DECISION DELEGATED TO HEAD OF PLANNING

Application No: H08-1097-21 **Applicant:** Fraylich Homes Ltd

Proposal: Details of external materials, brickwork panel, guttering, doors & windows, chimney stacks, existing & proposed site levels & floor levels, construction & surfacing details for proposed driveway & parking area and tree protection measures (Conditions 3, 5, 8, 9, 10, 13 and 15 of H08-0704-19)

Location: 59 High Street Gosberton Spalding

Proposed Construction and Surfacing of Driveway and Turning area

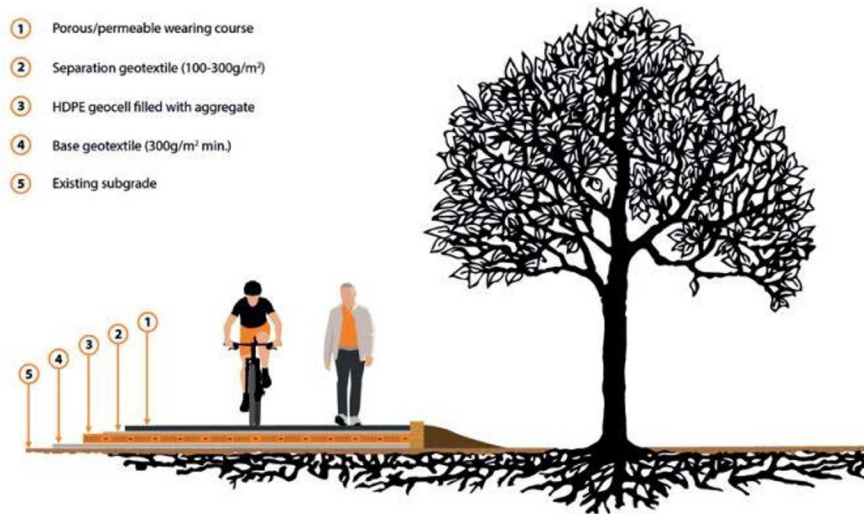
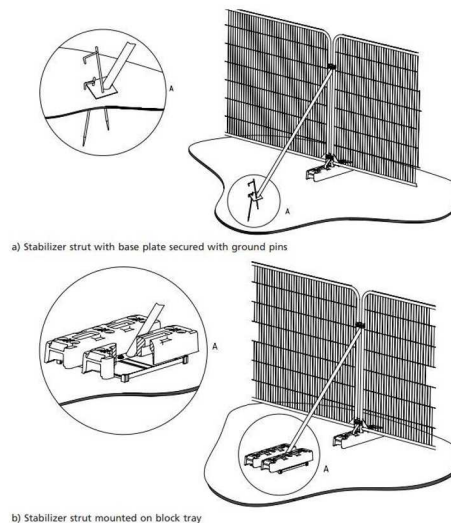
Ground levels have been provided, and are to be kept the same near the tree which is excellent. It would have been useful to have confirmed an actual measurement for the canopy spread of the tree so that we could see the extent of 16(i). There is nothing to indicate that the tree canopy as shown on the plans is just a stylised indication or an actual measurement. This will have very relevant implications when it comes to the space available for construction purposes. It is noted that although much preferred the Root Protection Area as measured in British Standard 5837:2012 was not referenced in Condition 16.

Further comment relating to condition 15 suggests that the details are sufficient, but that the applicant should clarify the depth of the driveway membranes, and also that perambulation should be avoided of the soil under the protected tree, and also suggests that the applicant be advised that the surface should be de-compacted.

The Trees and Nature Conservation Officer has been consulted and does not raise any substantial concerns. Therefore, this condition can be discharged. However, it is advised that due to the proposal to set up protective fencing only after site preparation, perambulation or storage on the grass within the root protection area, and also any pre-existing hard standing in such an area should be de-compacted.

Further consultation with the applicant has confirmed that the heras fencing will be emplaced prior to site prep, and decompaction will take place. Therefore, this condition may be discharged.

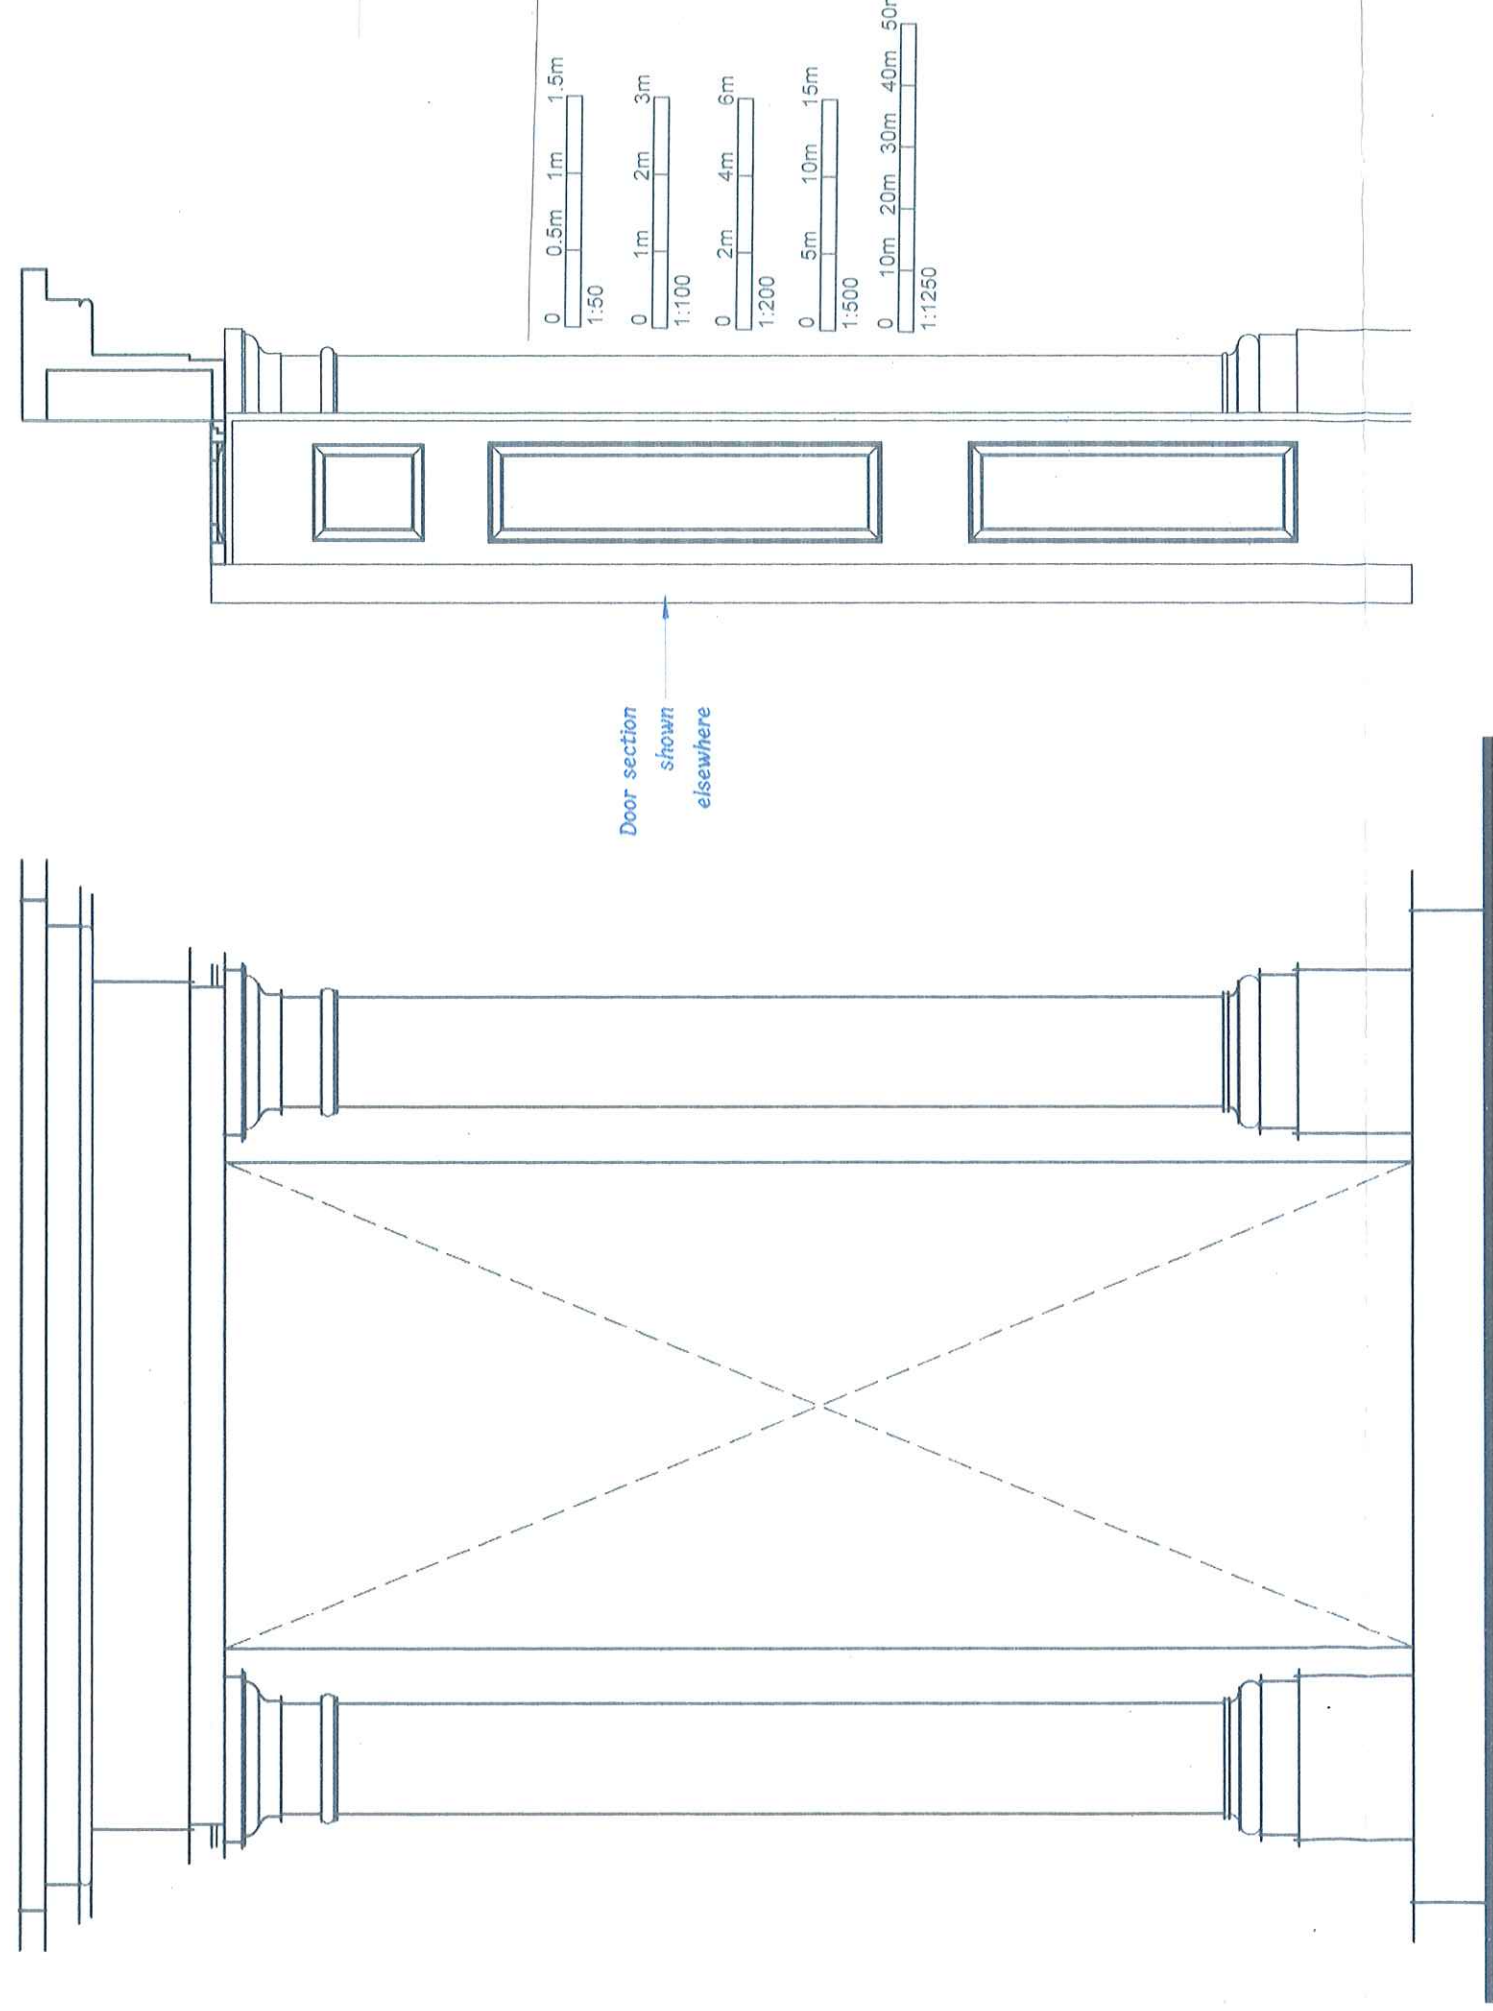
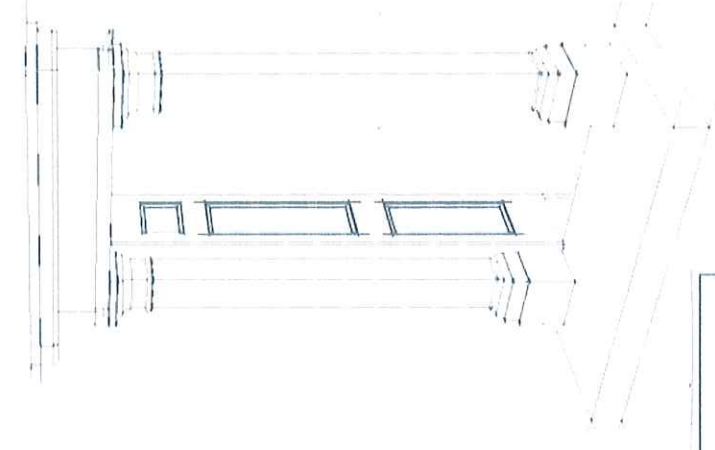
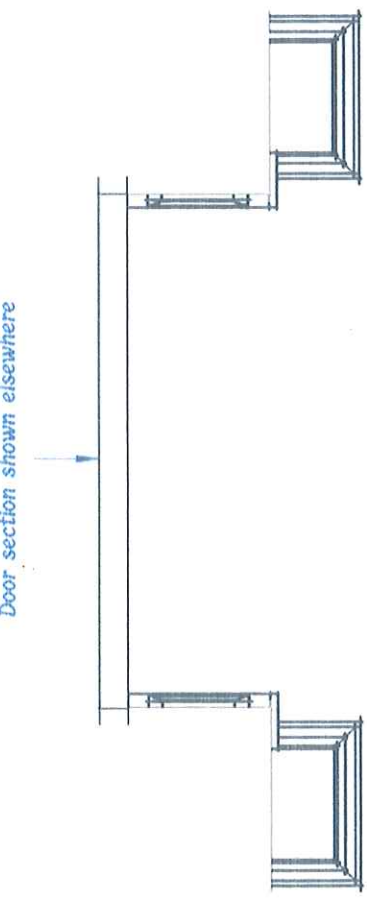
The details submitted of the door and window arch, door frame and chimney appear to be commensurate with the requirements of the condition and therefore, are satisfactory to discharge the condition.

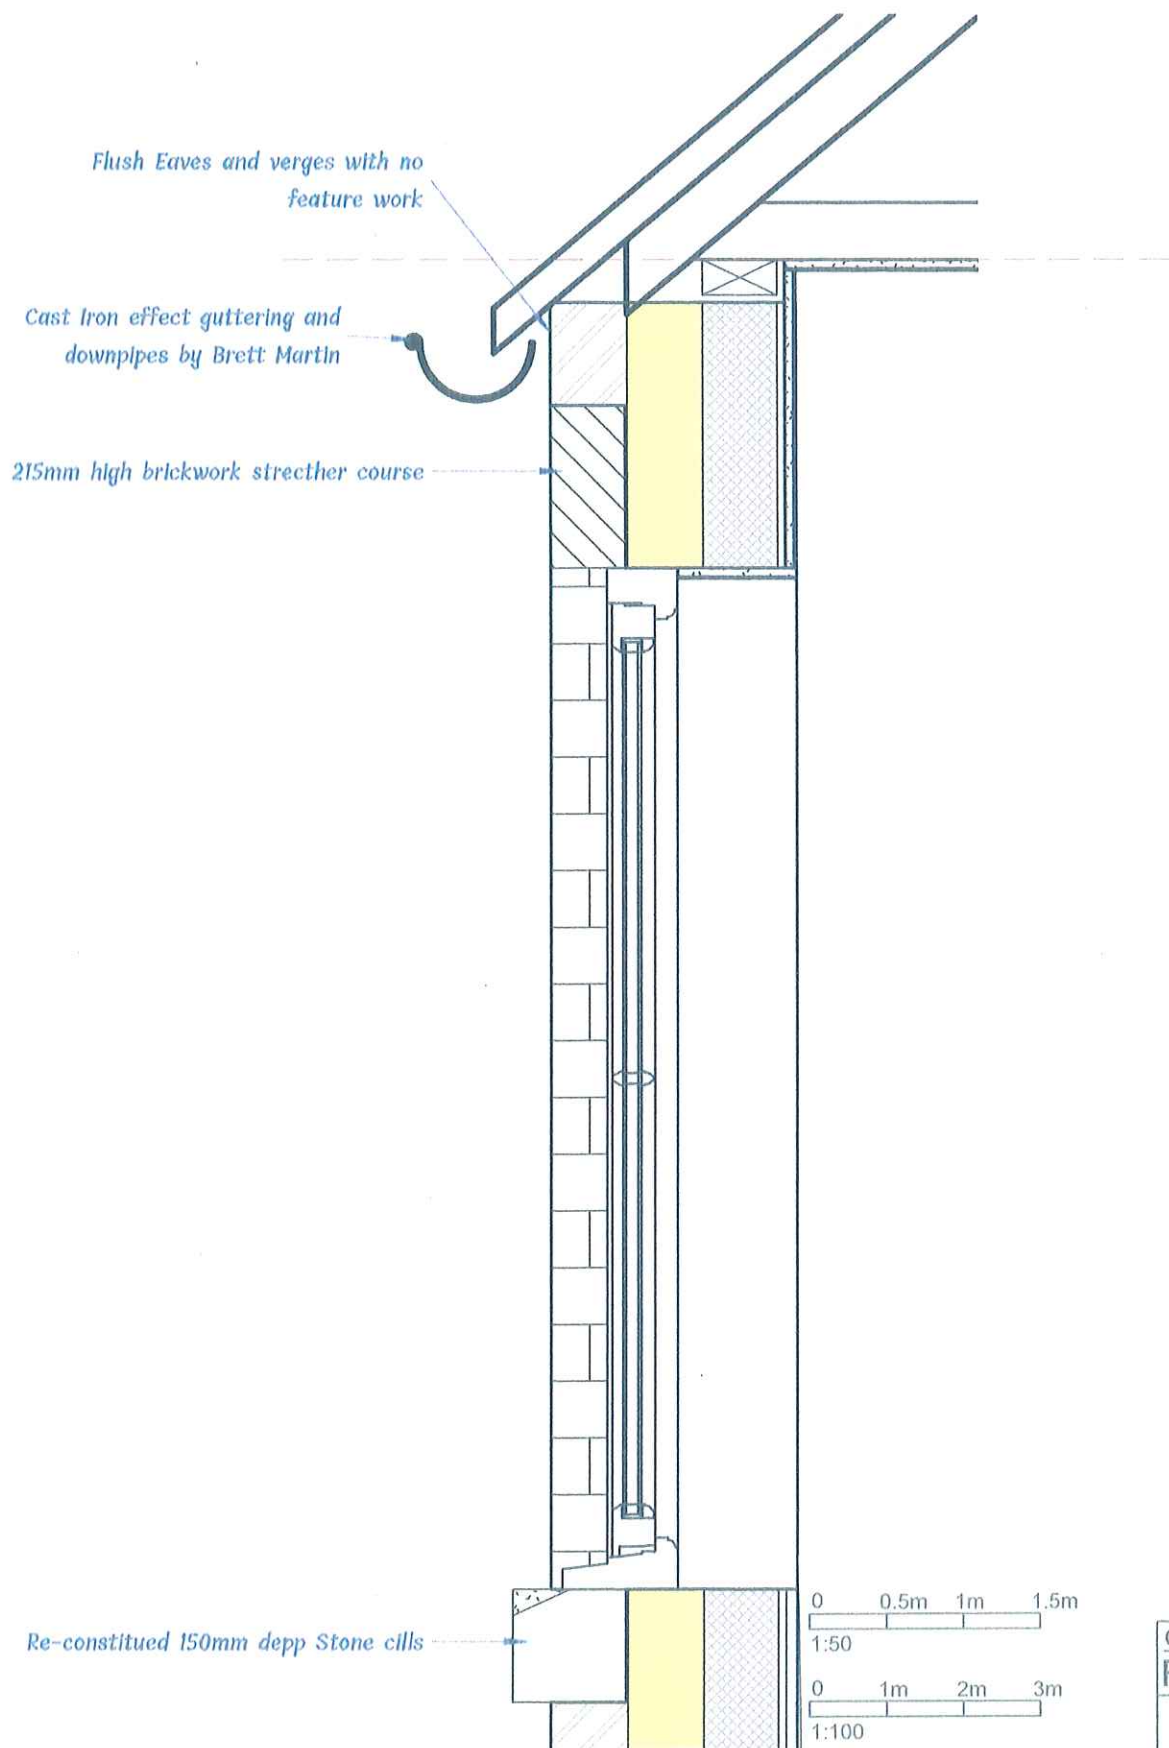
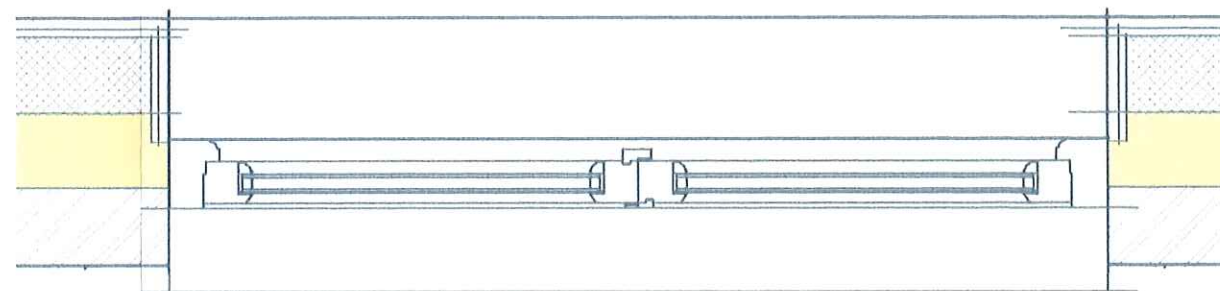
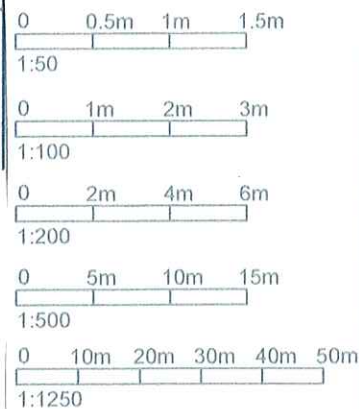
The details of the windows and doors have been submitted and are of timber, painted construction, fitting the requirements of all previous conditions, and therefore, the details are commensurate with satisfying the condition and therefore may be discharged.

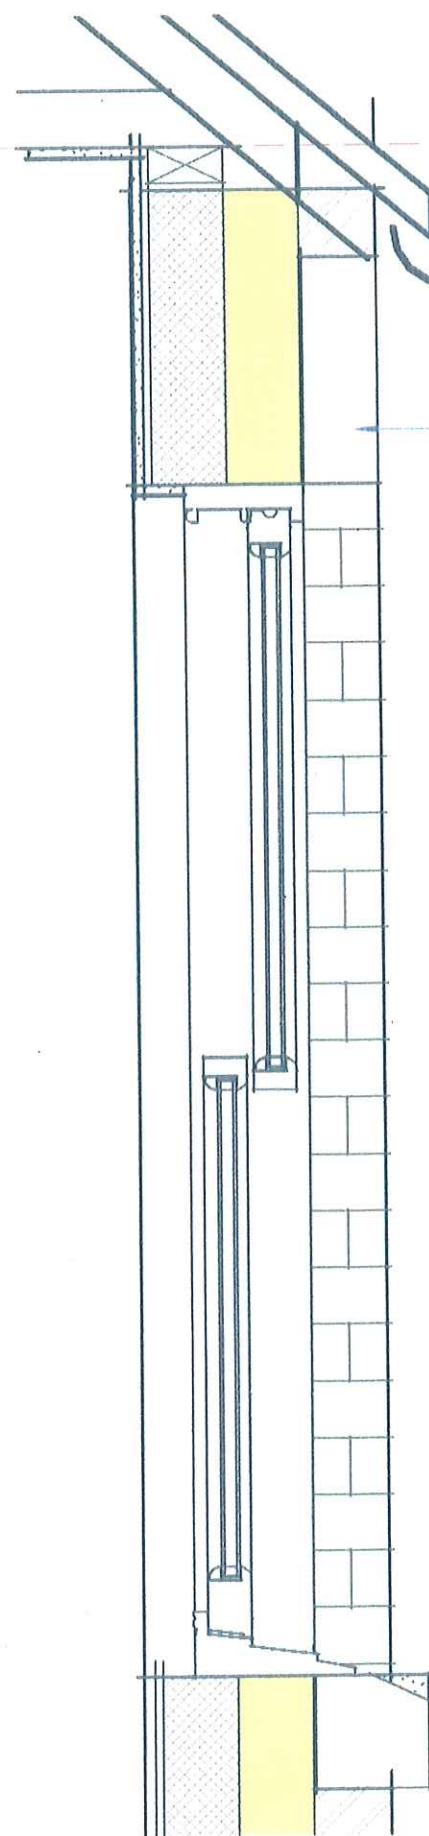
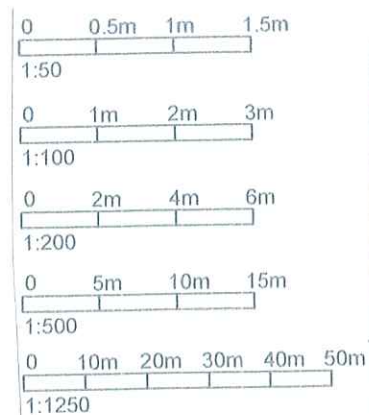
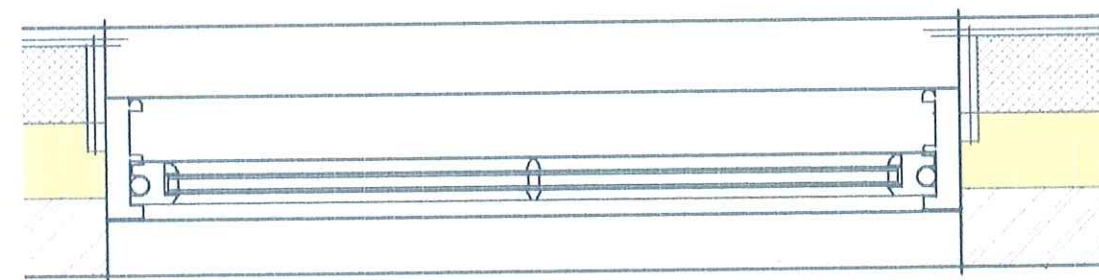
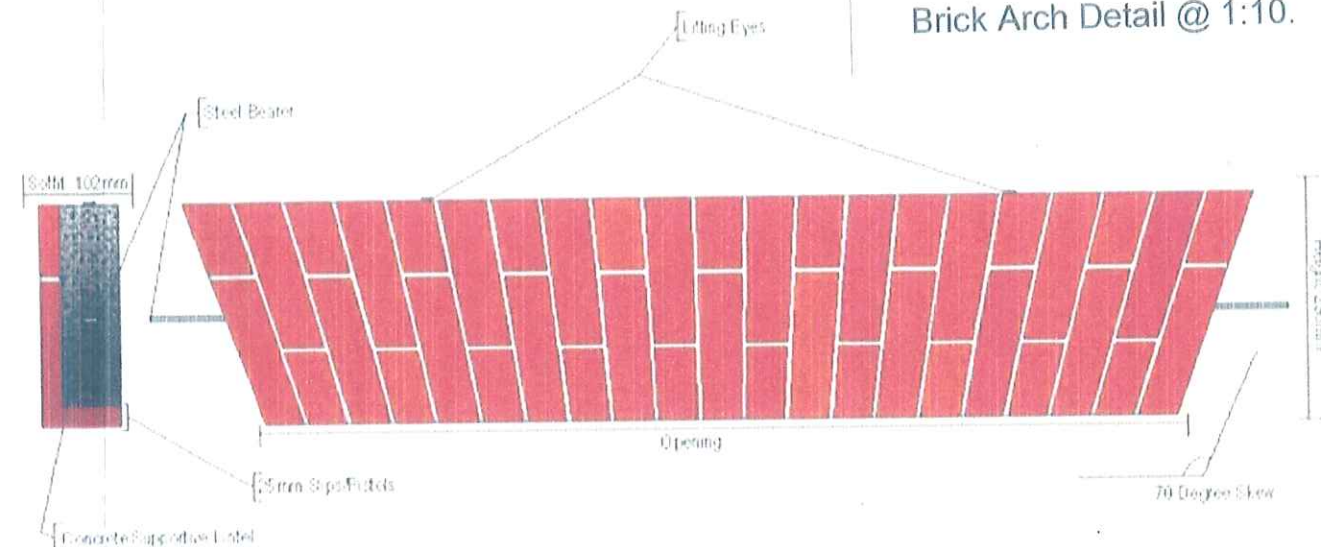
The window details provided are commensurate with the requirements of this condition and it may therefore be discharged.
